Plan 3/2012/0157 – New Multi Purpose Agricultural Building on Land Adjacent to Hothersall Lane.

Hothersall Parish Council

Scale 1:500

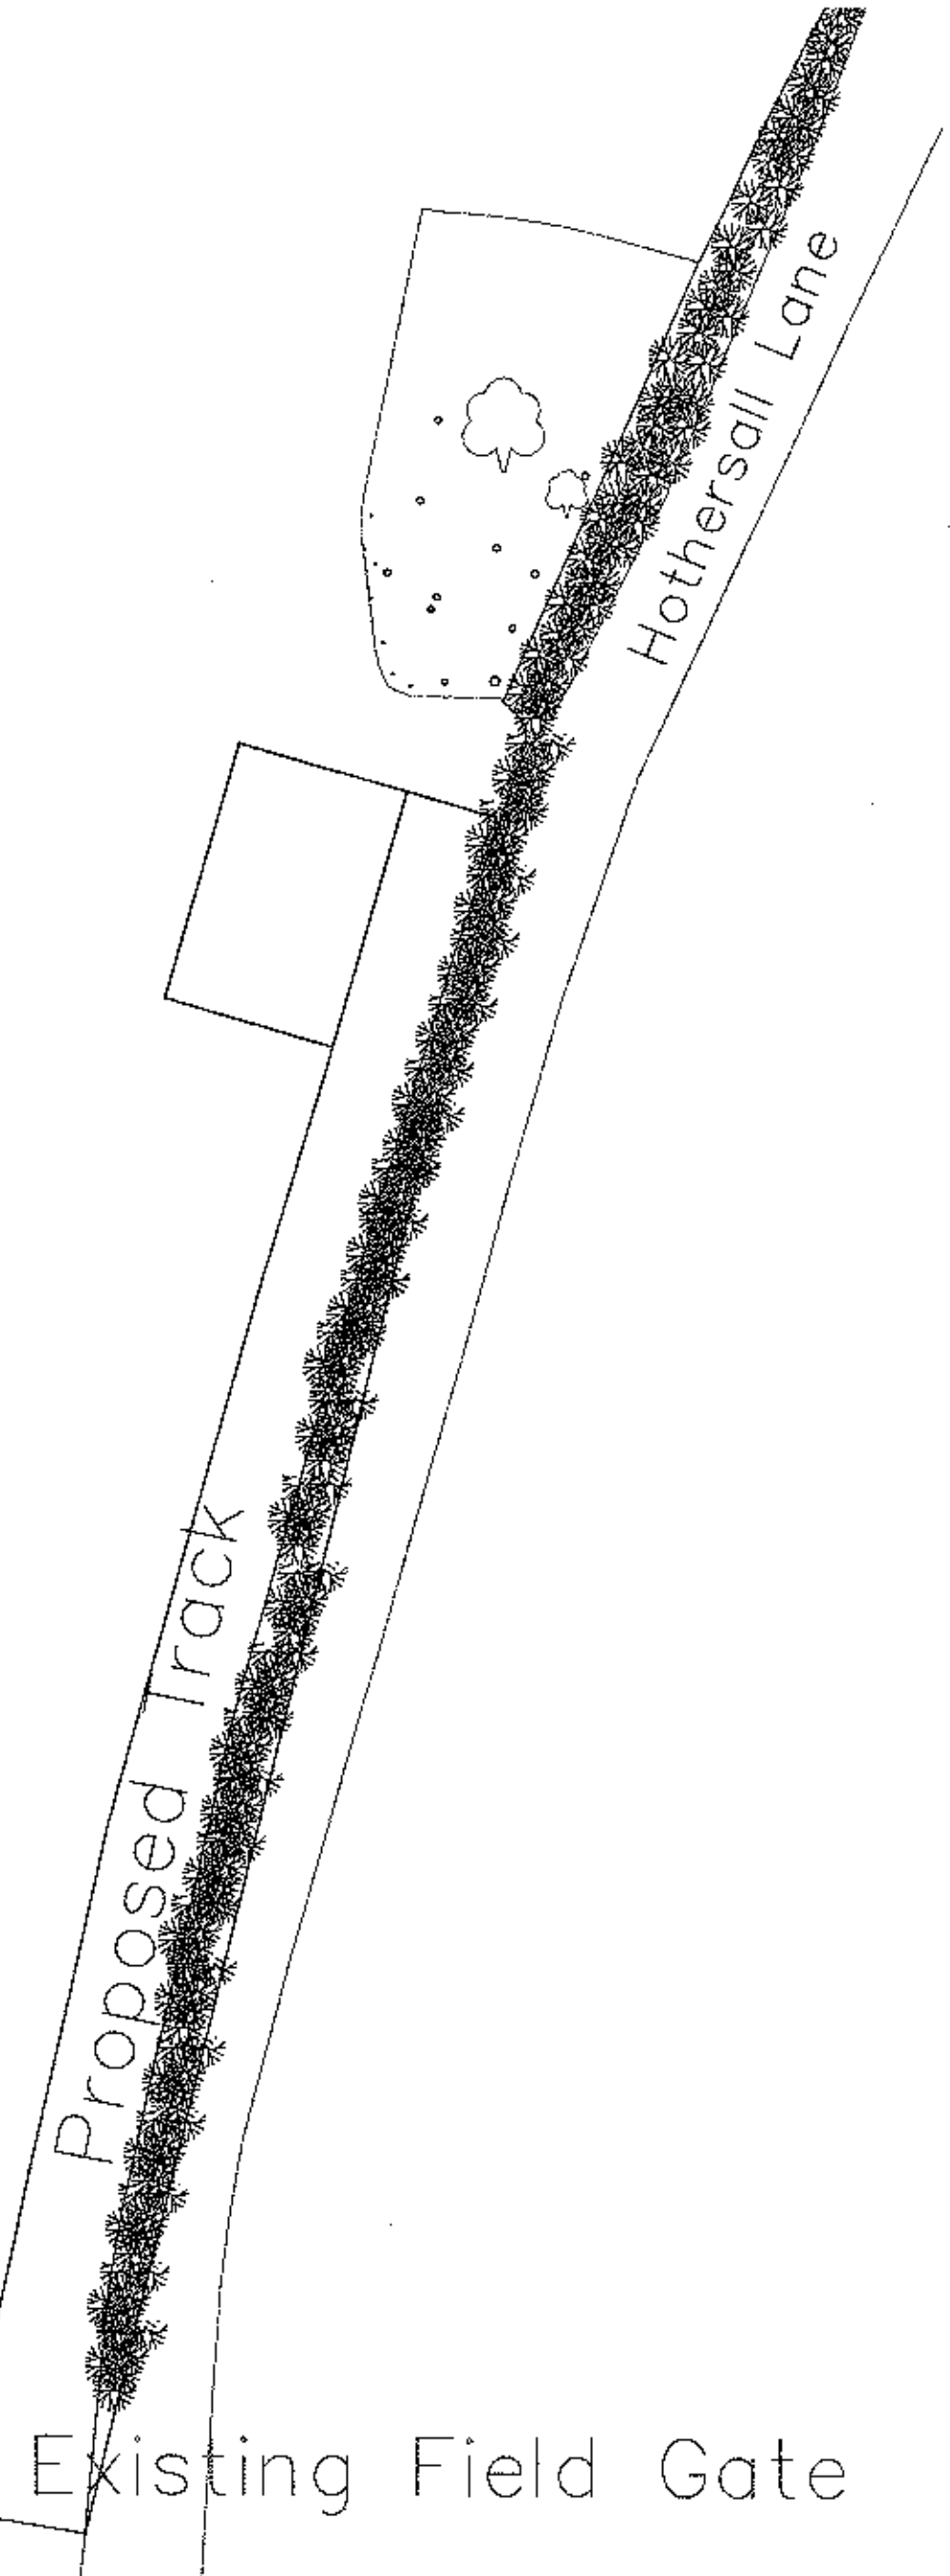
Thank you for your letter of 25th October and for the amended plans. It is noted that the new building will be placed on an 'existing track to be extended... The existing track was put in place a few days before the submission of these latest plans. It is not clear whether the track has been extended. Unfortunately the plans do not show the site of the new building by referring to its distance from a fixed point – namely the gateway entrance from the field in to Hothersall Lane. This distance is important because the closer the new building is to the Lane, the greater its adverse visual impact.

However this Council has no objection to this set of plans in principle but if permission is granted it is suggested that a condition is attached:

'The new building shall be placed in the south west corner of the field shown on the plans. REASON: For the avoidance of doubt and to minimise its visual impact on Hothersall Lane.'
